**Our Ref: FP/184/11/
Your Ref:**

**Installation of double glazed windows
78A Felpham Road Bognor Regis**

Scale 1:500

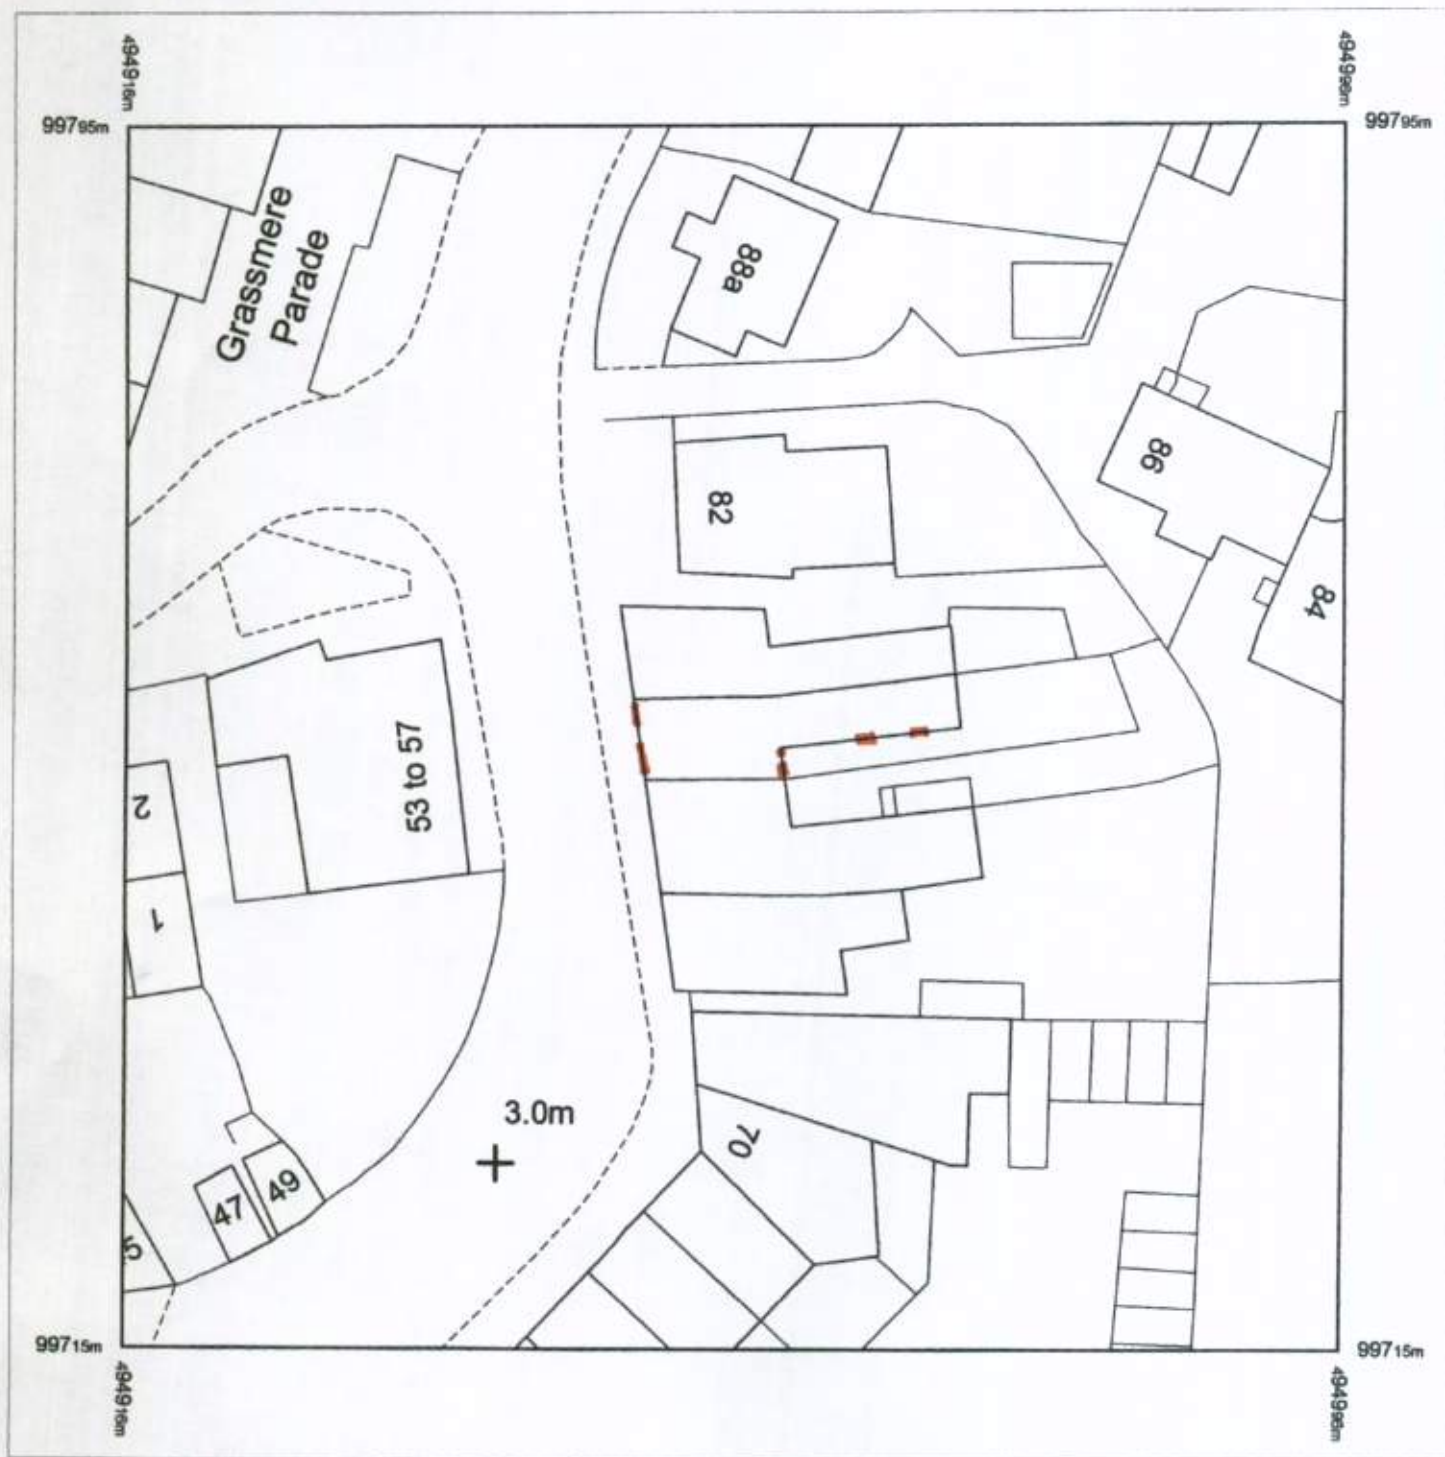
I require 1 electronic or 3 paper copies of a revised block/site plan to show the proposed works clearly highlighted, in accordance with the guidance notes available on our website detailed below (click on National List).
